APPLICATION NO: P/133/07/

Registered: 23-OCT-07
Site Address: 10 The Parade Bognor Regis West Sussex PO21 4TW

Description of Works: Continuance of use without compliance with condition no 2 imposed under planning reference P/15/96 to change from cafe to general A3 use of premises.

PROPOSAL
 EXISTING
 + PROPOSED

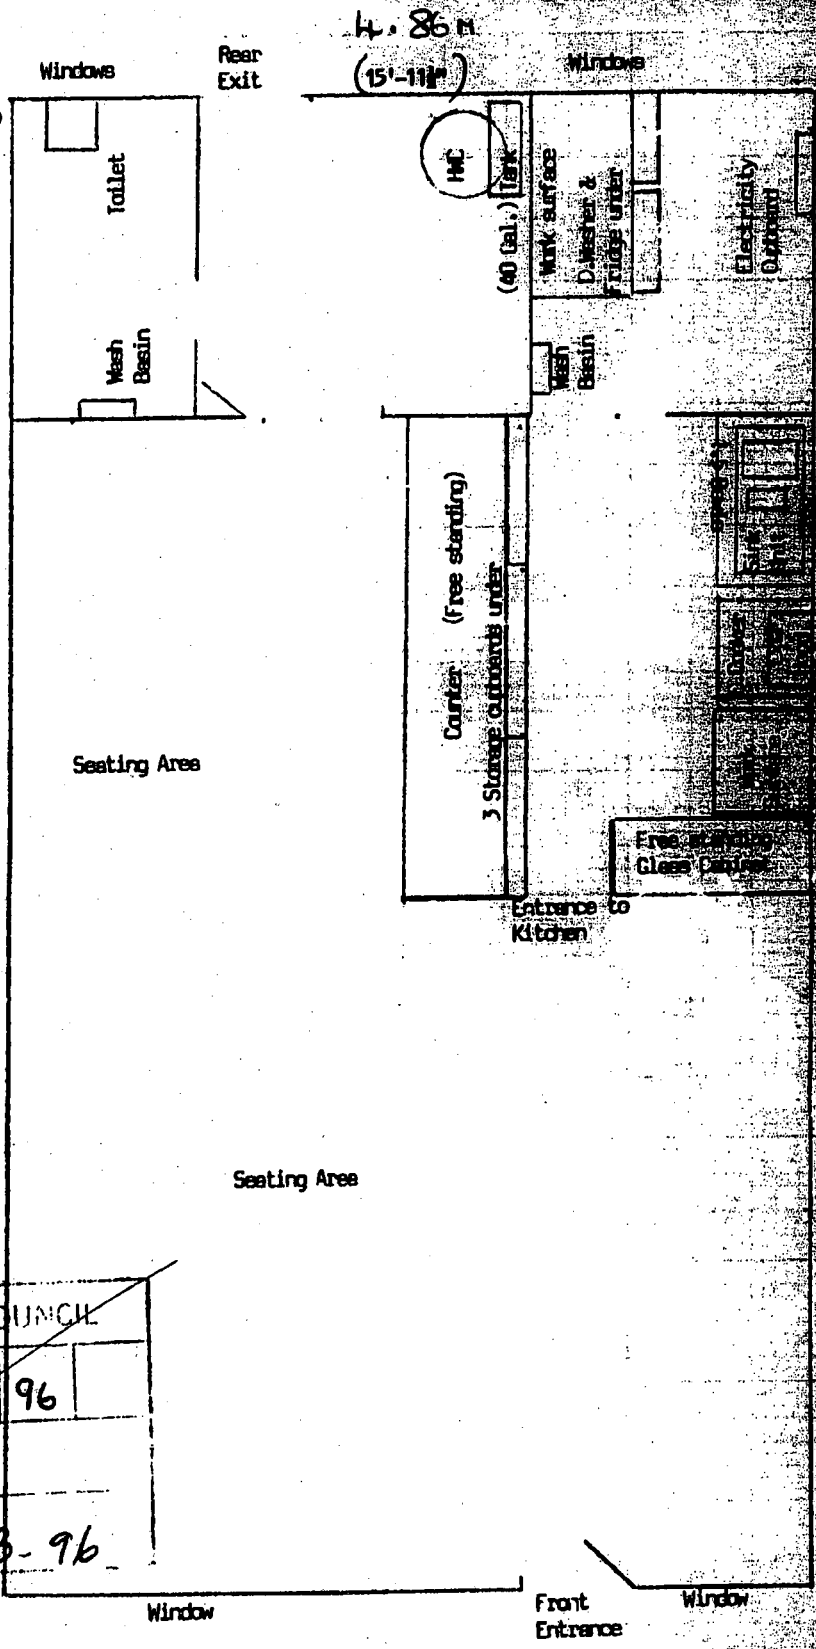
Noted proposed extract system, supplier; Ves are known manufacturers and system does indicate inclusion of bag filter and carbon filters. Manufacturers drawings do not include their information on extract rate, decibel levels or dwell time. letter from installer indicating only 12 air changes per hour, which is too low for a commercial kitchen. Original drawings do show a very small kitchen and cooking area, and lack of adequate sanitary accommodation for customers .

Unit 10, The Parade Extraction Unit Details

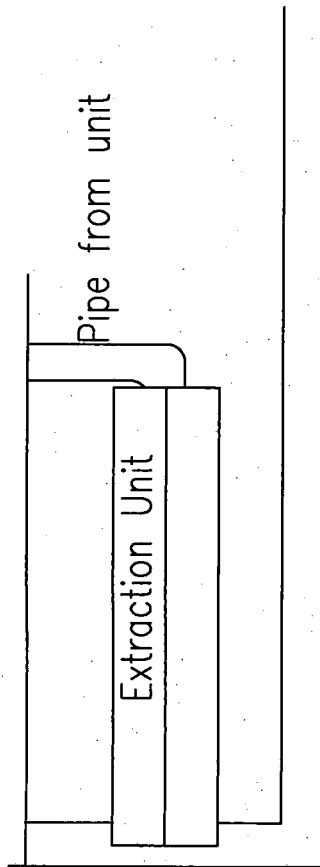
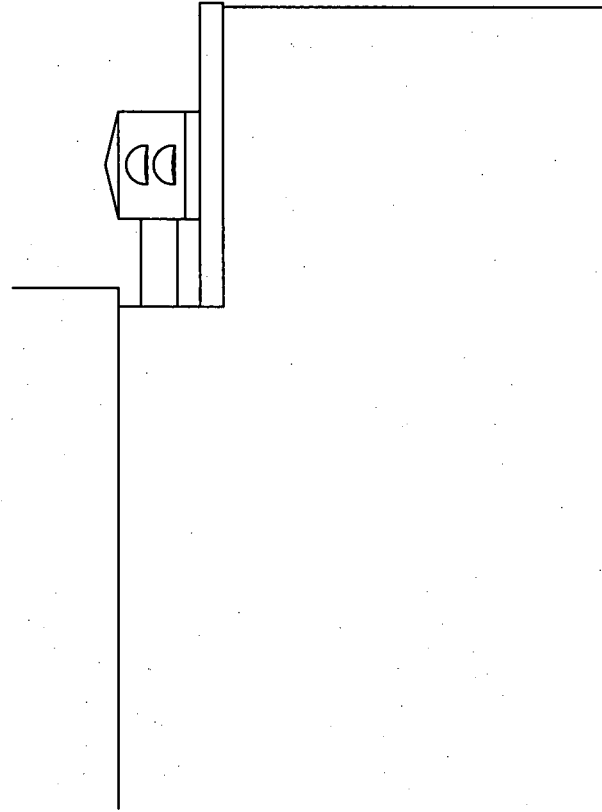
The information on the exhaust system supplied in the current application is however totally inadequate.
